## **Blaze-Inn Saddles**

**Planning Application: 21/04166/F**

### **Rebuttal to the Objection from Barn Close:**

SKETCHED VIEW FROM STREET THROUGH BURDROP

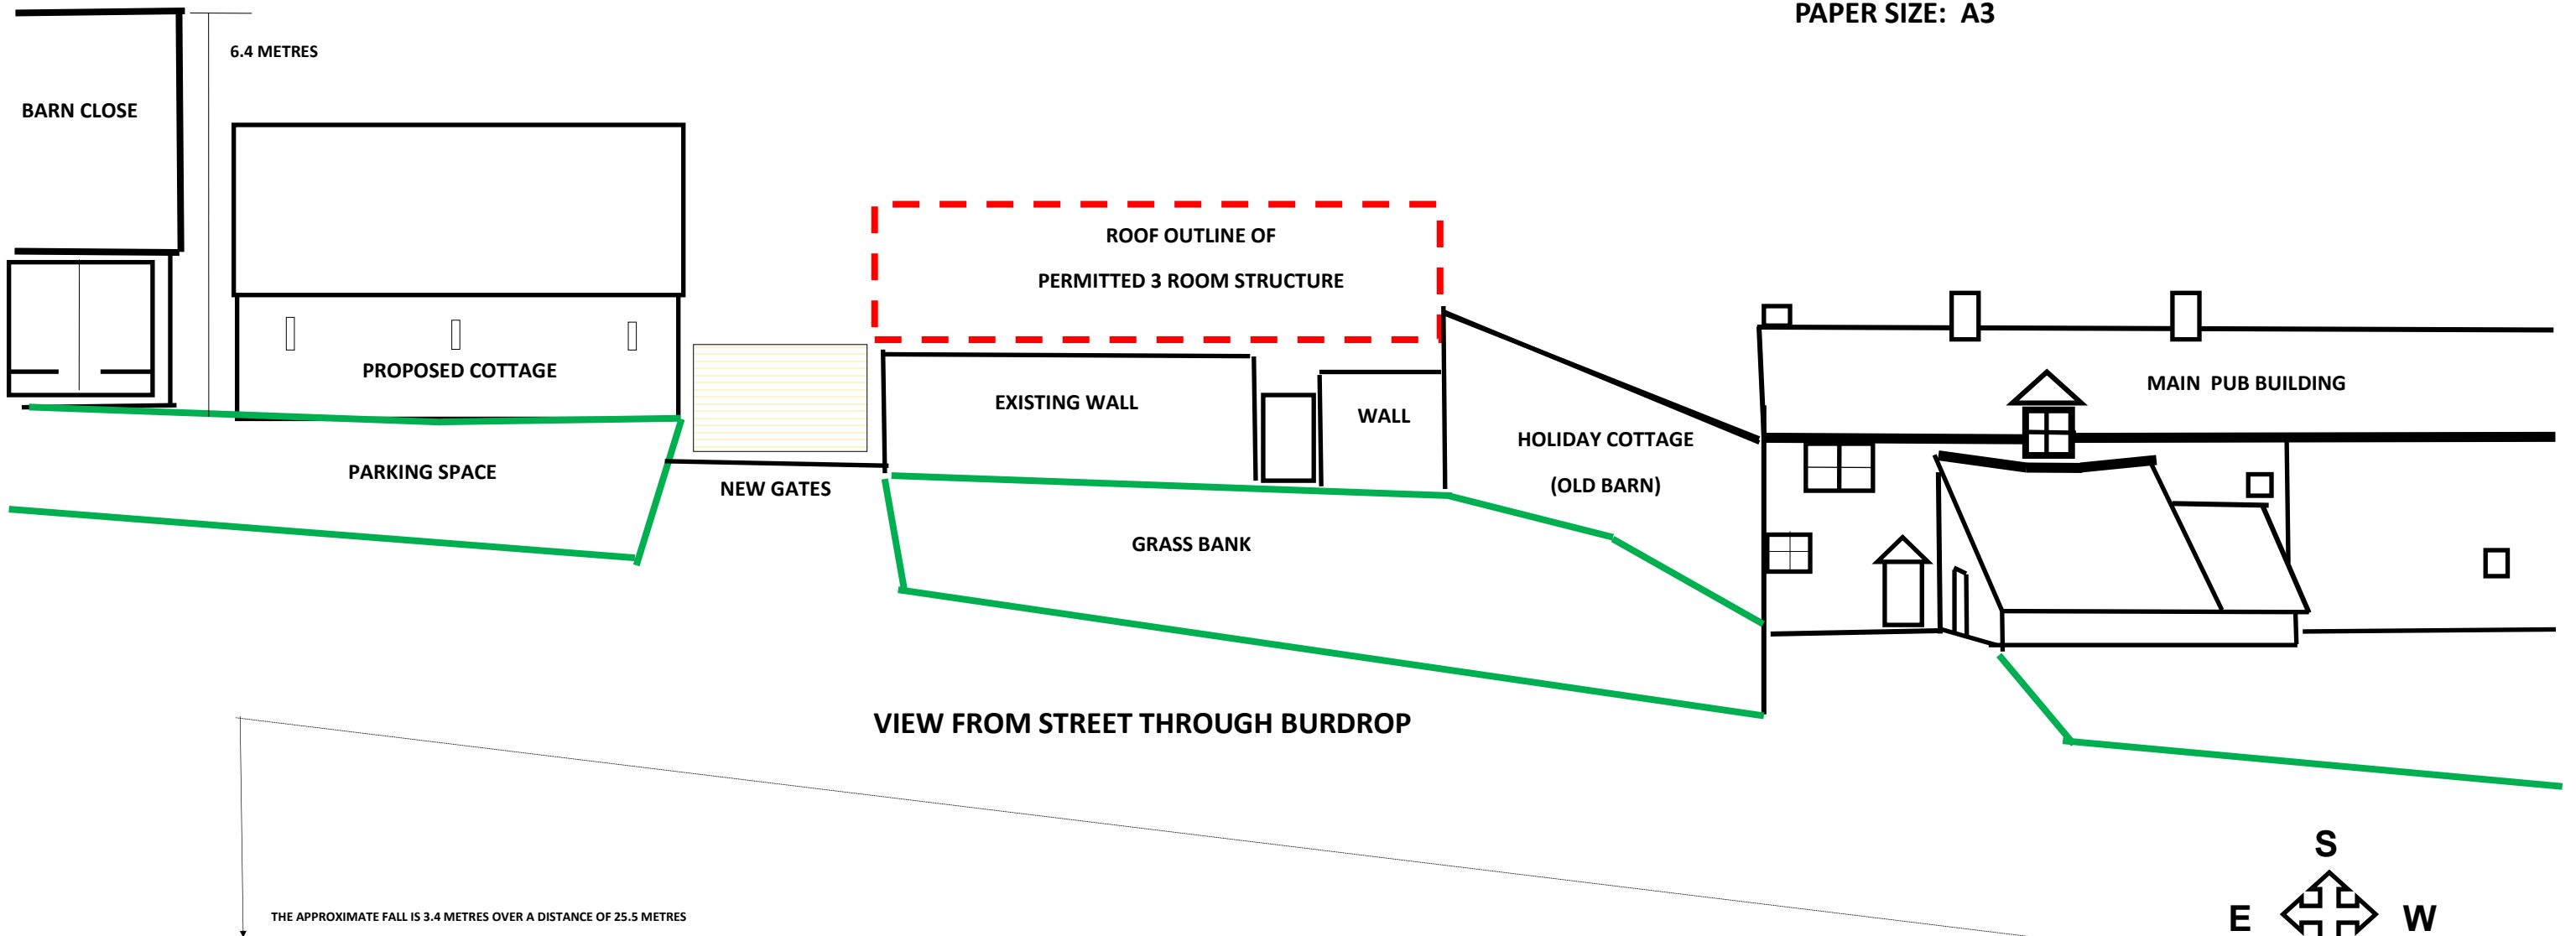
*As an owner/occupier of the adjacent grade II listed property Barn Close I object for the following reasons: The building is sited too close to a fragile listed building that would not allow space for any essential stone wall repairs and would compromise the reading of a historic building from the street by altering its form in relation to other buildings. It was and always has been a sizeable length upon road with a thatched passage at the midpoint (approximately), this proposed addition would negatively affect these historic proportions.*

*This scheme is not well thought out and is significantly different to the previous proposal. I note there is no accurate scale on the sketch but it appears to be sited within 1 metre of the gable wall of Barn Close. Whilst this may occupy a previous footprint, that footprint would be an agriculture barn. Which would not have humans inhabiting or have had windows at first floor level, these proposed windows will overlook directly into our property and cause a loss of privacy to a large mature garden and as the proposed dwelling extends beyond the listed barn it will also directly overlook the rear of our house causing loss of privacy to the dwelling.*

**There will be a distance of at least 1.8 metres between the 2 buildings which allows for any stone wall maintenance, in our view the historic proportions will be restored and not harmed in any way.**

**The scheme is extremely well thought through and that is why it is different to the original proposal; [REDACTED] Barn Close will NOT be overlooked and that there are no windows facing their property from any floor level.**
